CITY OF ALBUQUERQUE

March 31, 2021

RE: **Lot 17 Block 1 Unit 22 SAD 228 Volcano Cliffs Subd.
8015 Agua Fria Ct. NW
Grading and Drainage Plan
Engineers Stamp Date 10/29/2020 (D10D003N17)
Pad Certification Date: 3/11/2021**

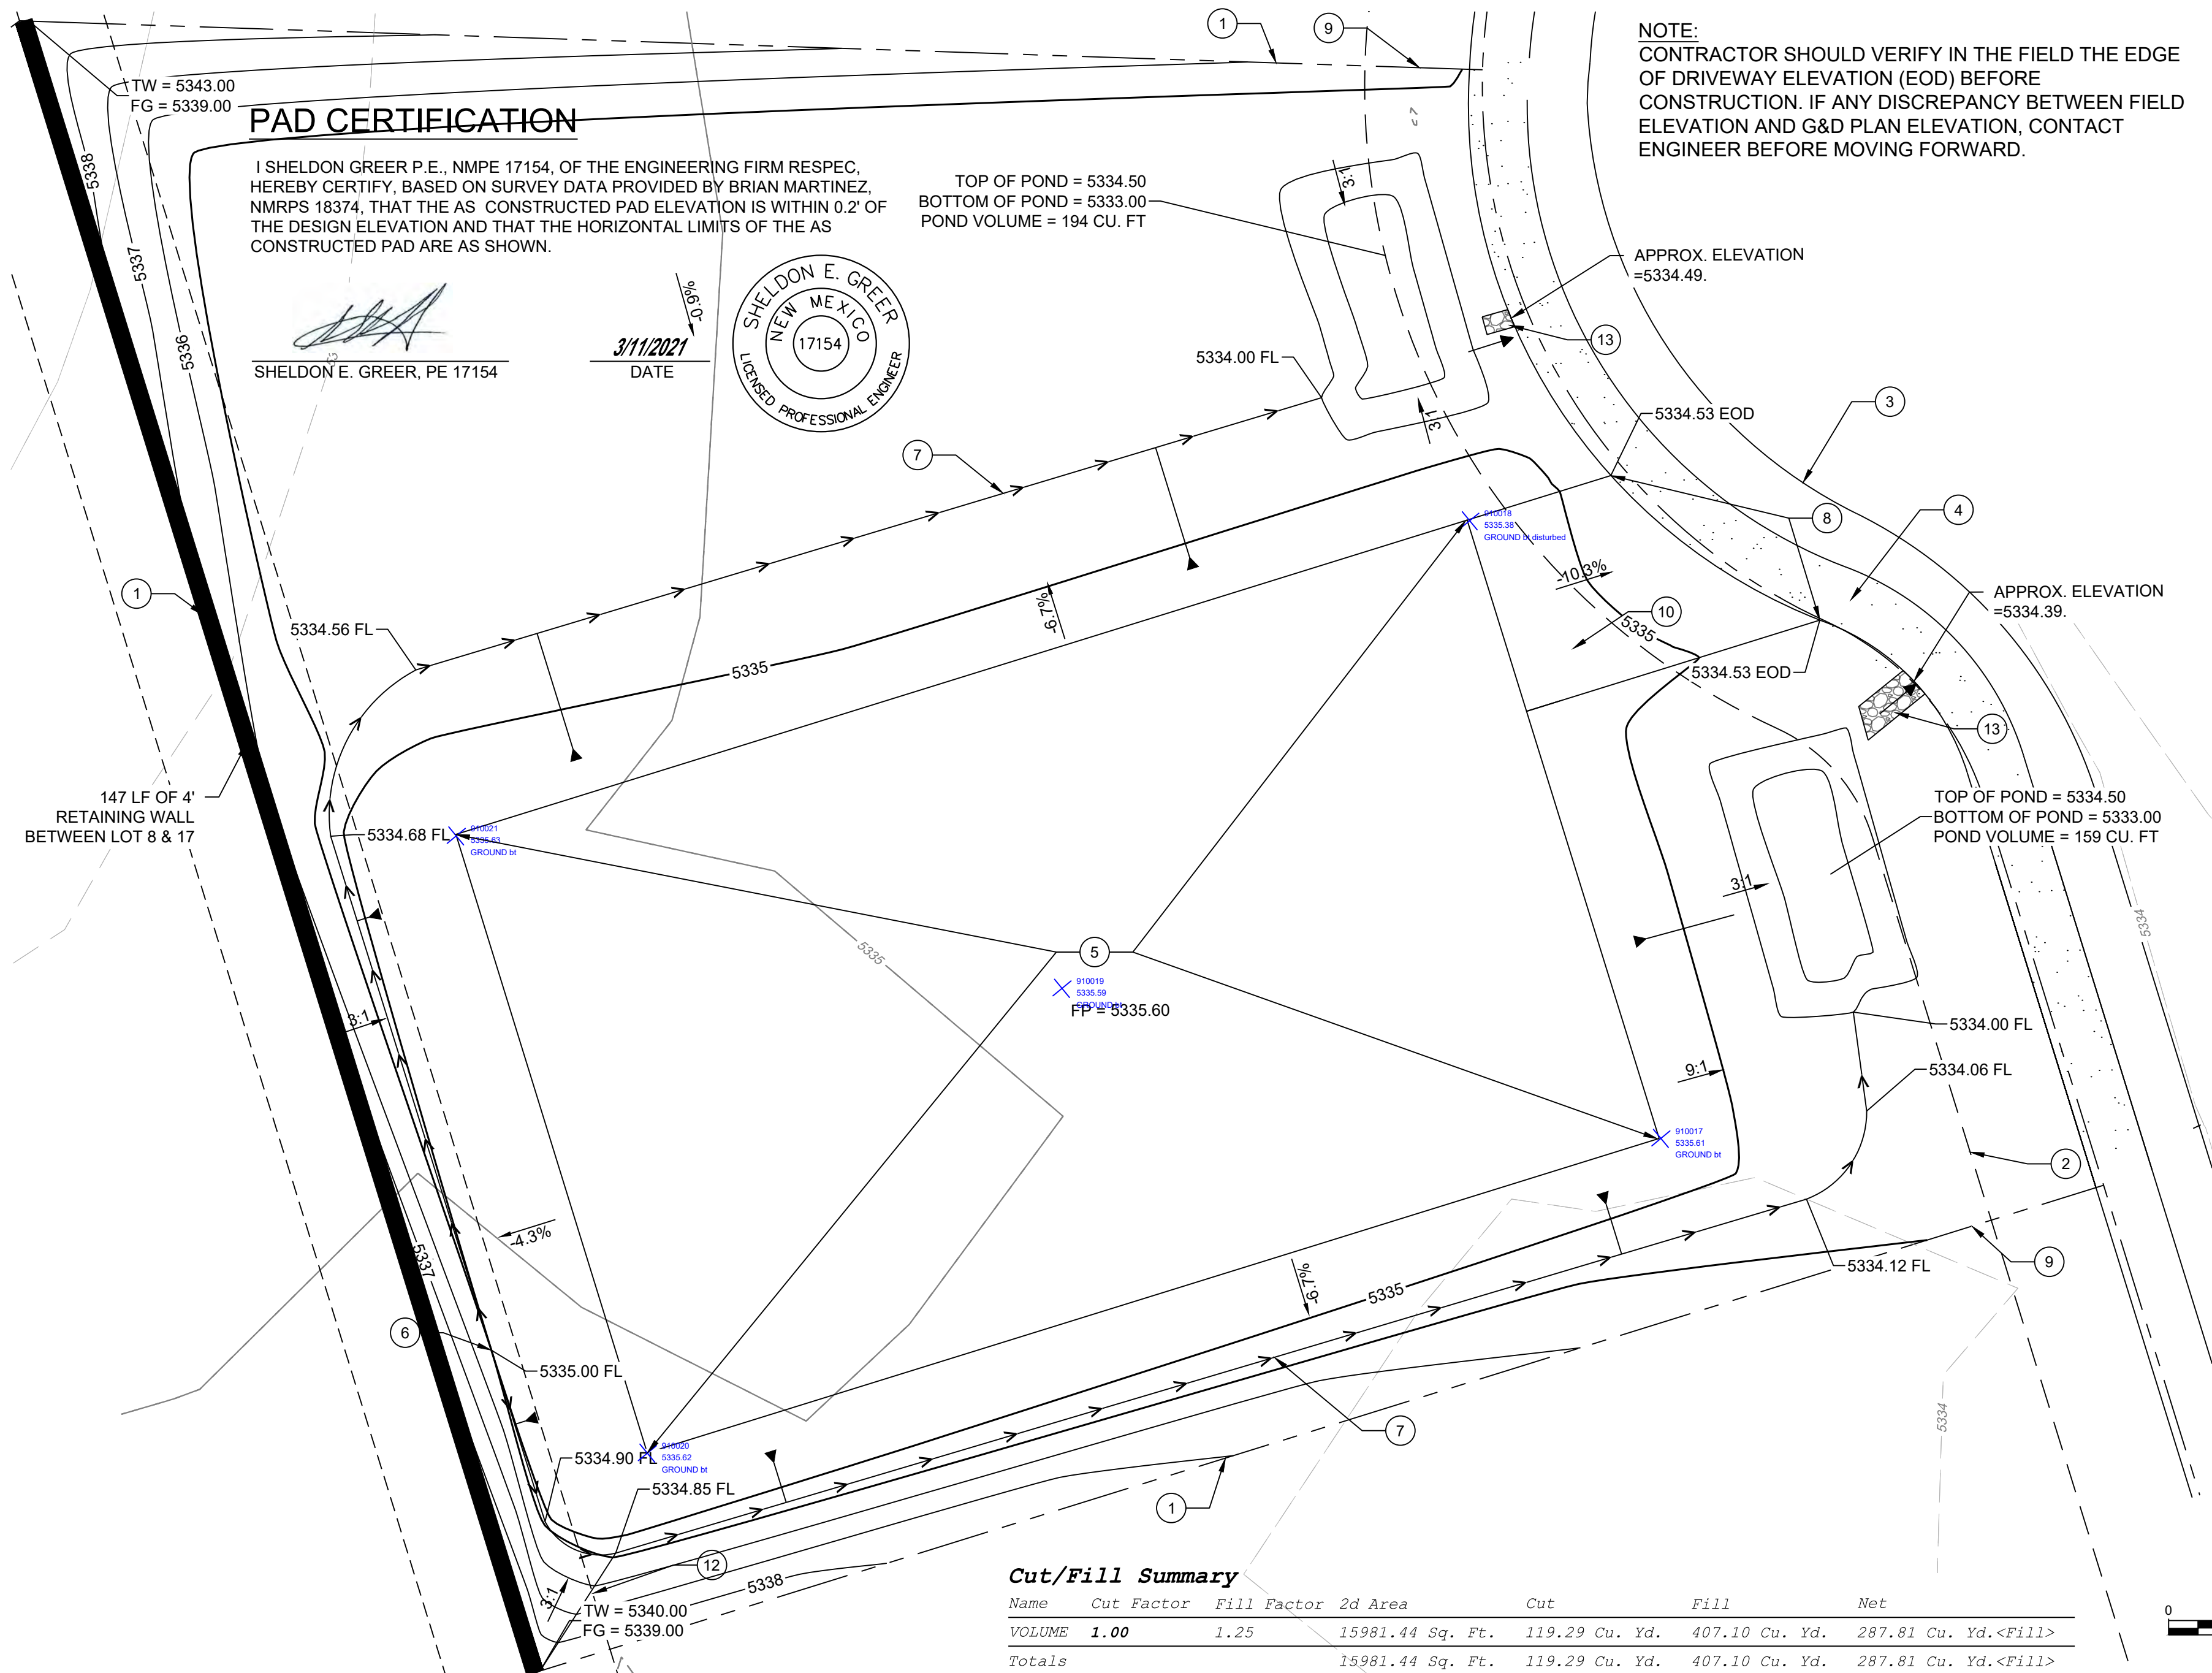
- Remove all dirt from the street. Dirt is not allowed to use as a ramp for going over the curb, only lumber or crusher fines are acceptable.
- Remove the dirt in the channel, it is blocking the flow from Alto Rey Ct. to Agua Fria Ct.
